Consultee Comments for Planning Application

SDNP/24/00451/FUL

Application Number: SDNP/24/00451/FUL

Proposal: Residential development of 4 x 3 bed houses & 3 x 2-bed houses with associated bin/bike storage & parking

Project
 The Watermill,
 Halfway Bridge, Lodsworth.
 Drawing
 Proposed Site Sections + Elevations - 1
 Date
 october 2023
 Scales
 1:100/200 @ A1/A3
 Doc No
 DLS-068-PL-04-A
 Drawn by
 Suitability
 planning
 Revision

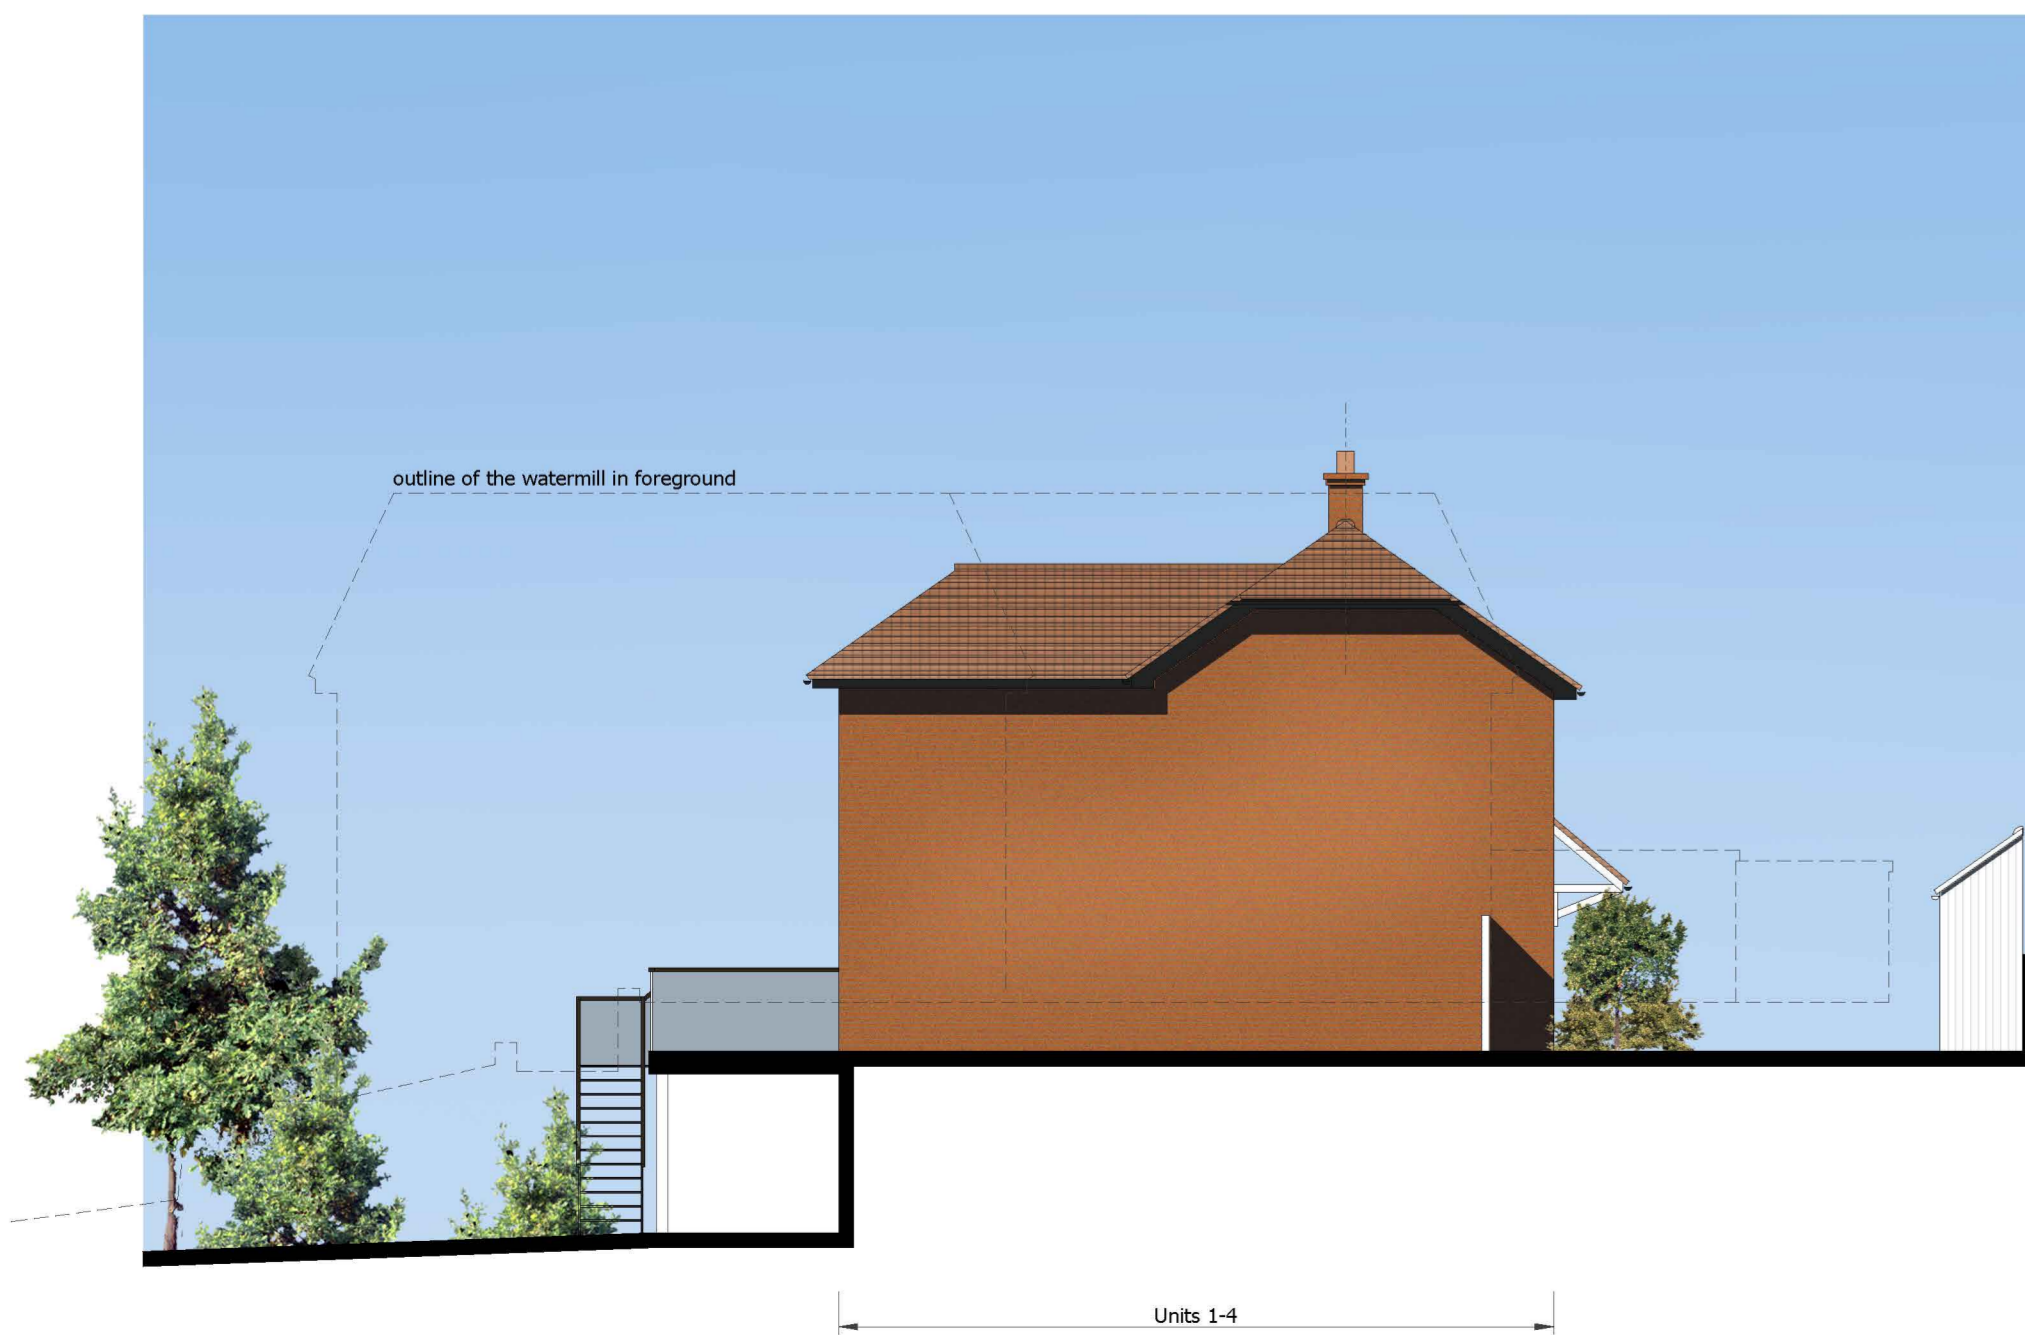
house more balanced, would be more appropriate to this location. The general design has some character and materials pallet of the surrounding area, however the building depths are too wide, requiring large expanses of flat roofs.

Drawing  
 Proposed Site Plan

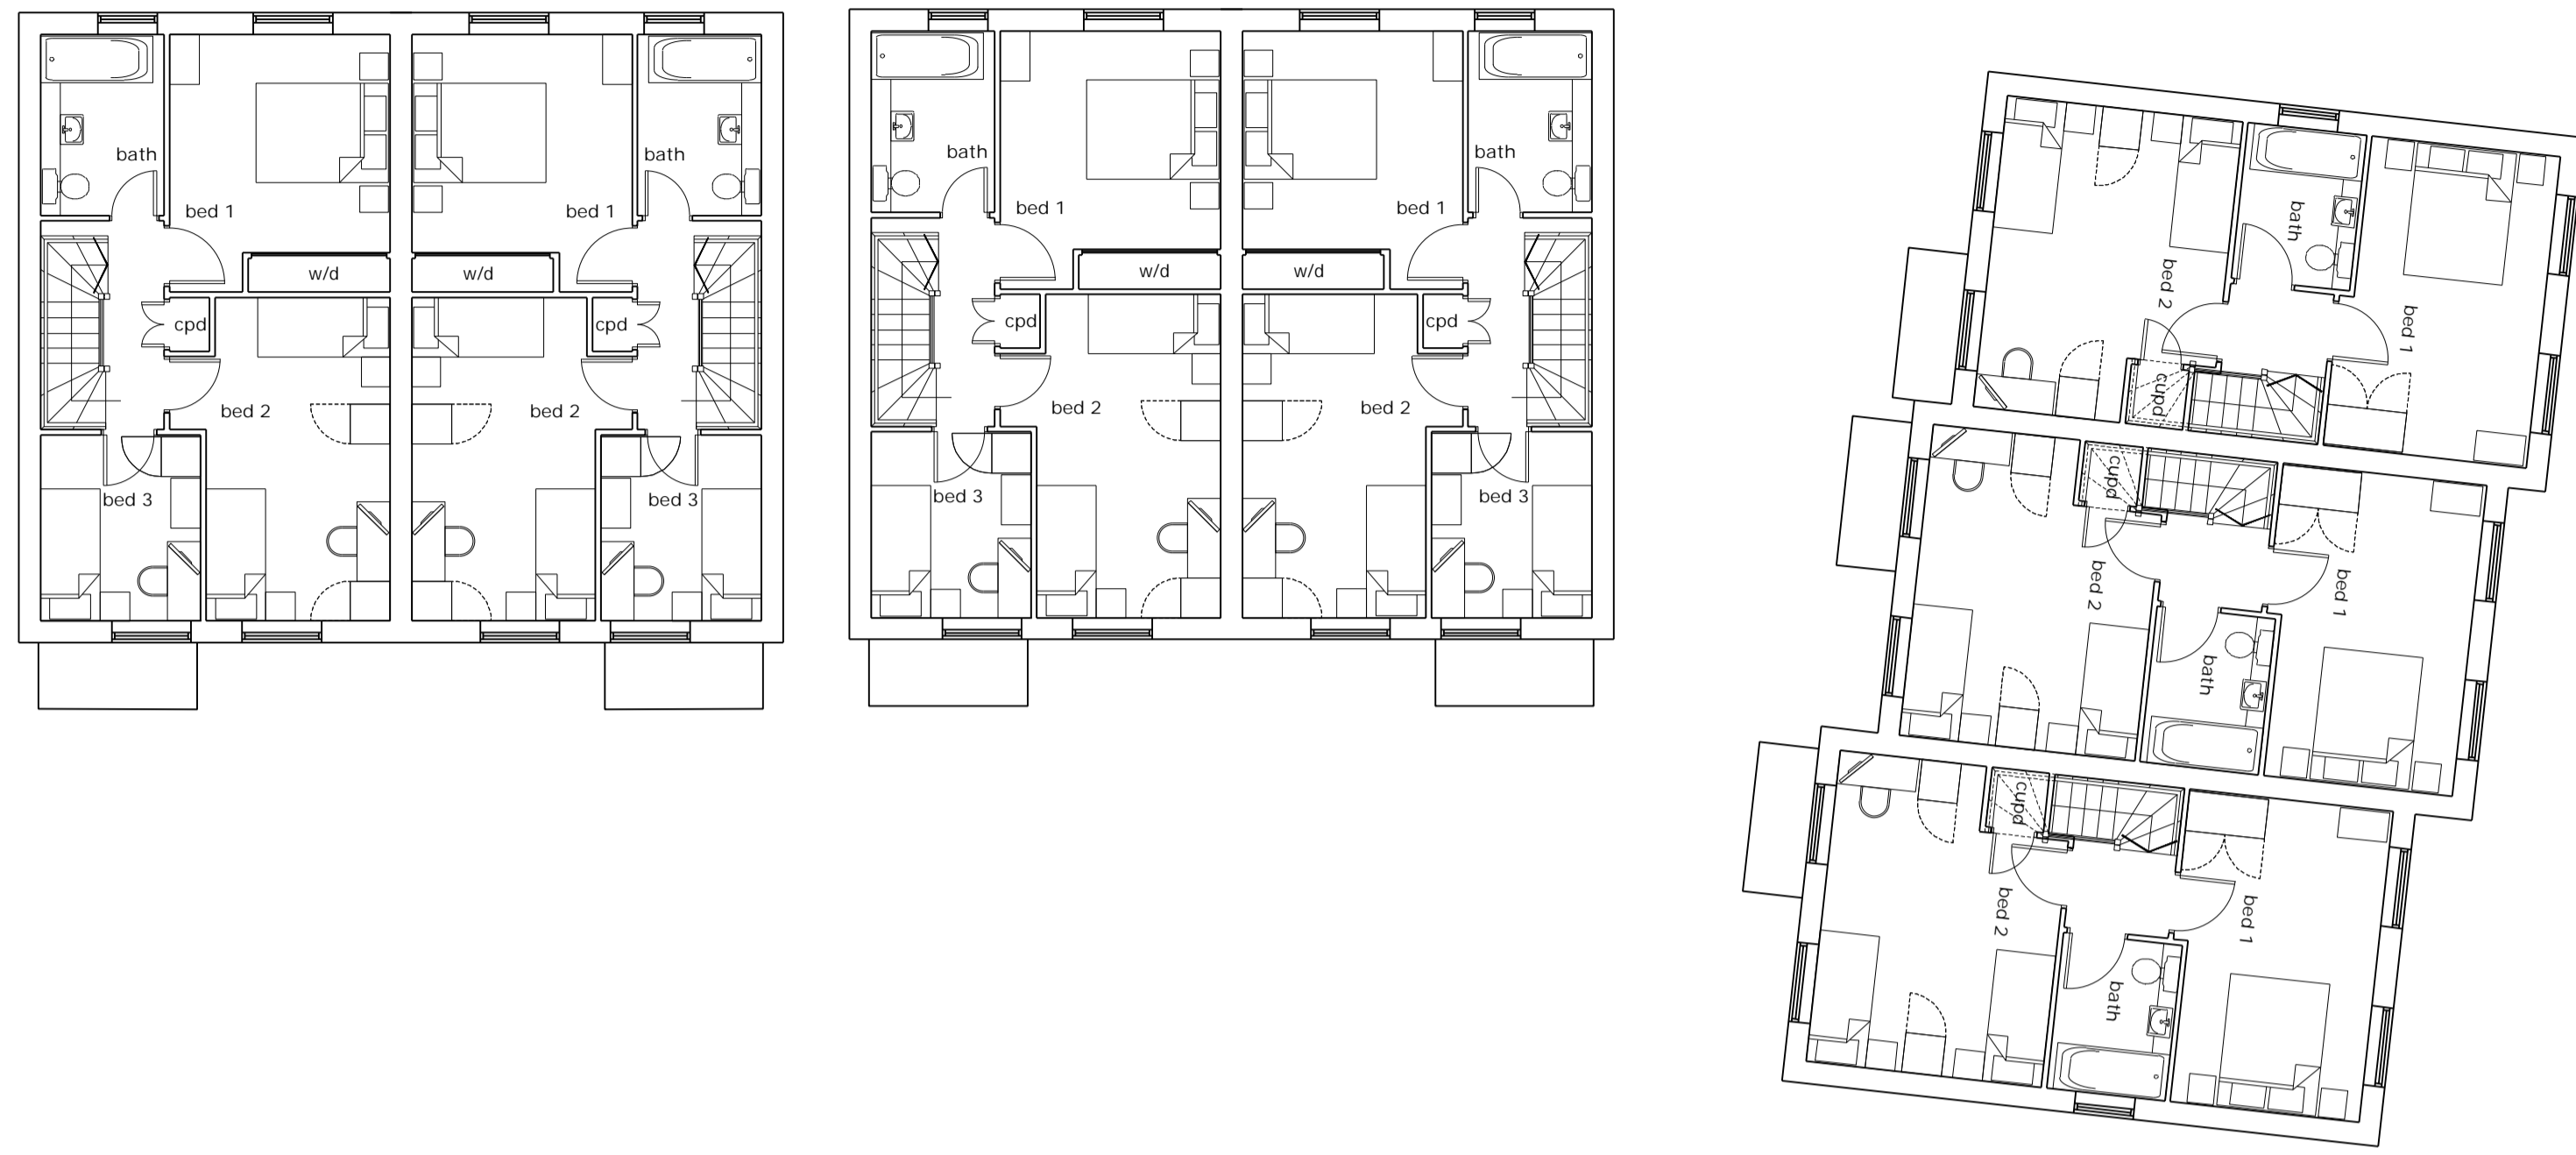
The proposed design layout is not in keeping with the character of the hamlet; the proposed block layout, and back land form are urban in character and do not match the form and context of the surrounding plots. The proposed design and layout is considered to be harmful to the character of the area and a less formal, more rural layout and landscape led one, with the density of garden to
